Project #: 1003859

**City of Albuquerque
Planning Department
Inter-Office Memorandum**

SUBJECT: Project # 1003859

On December 8, 2011, the Environmental Planning Commission approved Project #1003859 / 11EPC-40076, a Zone Map Amendment, 11 EPC-40075 an amendment to the Site Development Plan for Subdivision, and 11EPC-40074, a Site Development Plan for Building Permit, for Tract 5, Plat of North Andalucia at La Luz, zoned SU-1 for C-2, O-1 and PRD changed to SU-1 for O-1 Including Bank & Drive-in Facilities, located on Coors Blvd. NW between Learning Rd. NW and Montano Rd. NW, containing approximately 3.38 acres.

Drawing file: 1003859_Approved Plans / SDP for Subdivision Set 9.28.17.pdf

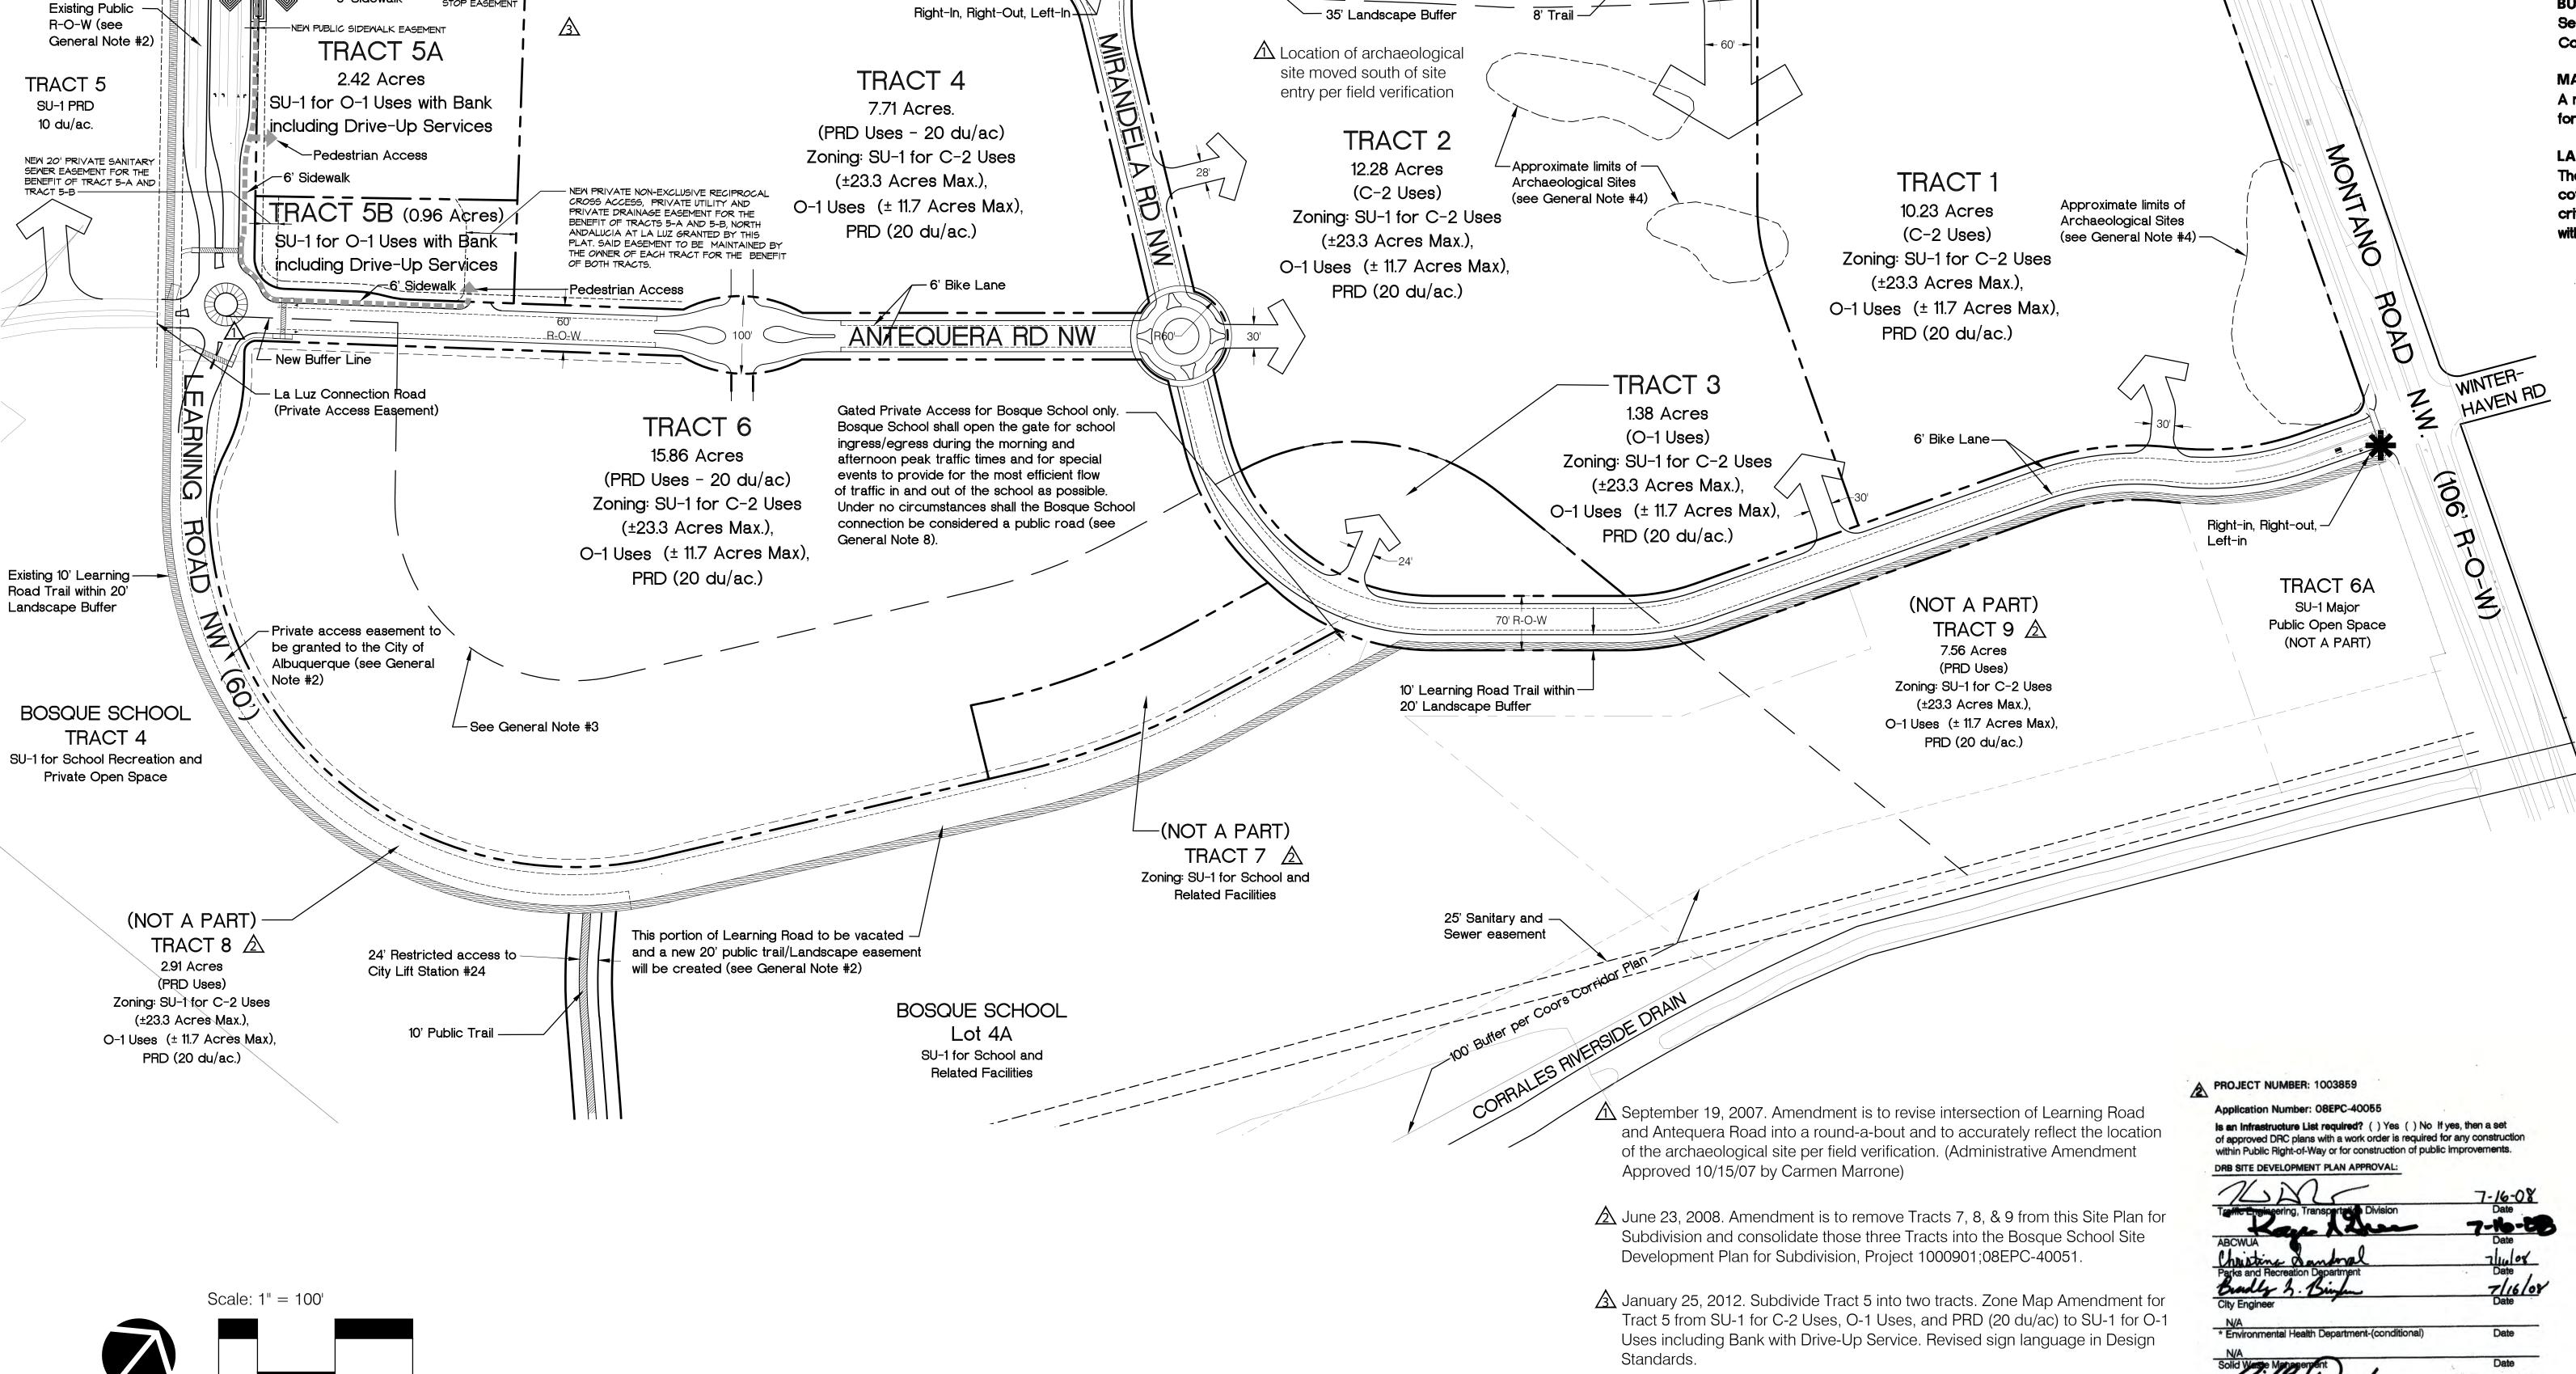
The applicant has satisfied the EPC conditions of approval for the amendment to the Site Development Plan for Subdivision and the Site Development Plan for Building Permit. Staff notes that the change to the Site Plan for Subdivision, page 3, "Individual Monument Signs" should be bubbled to indicate as new text associated with amendment number 3. There is also new text on Page 1 regarding two easements and Pedestrian Access that should also be included in the bubble so that it is clear that this is all new text.
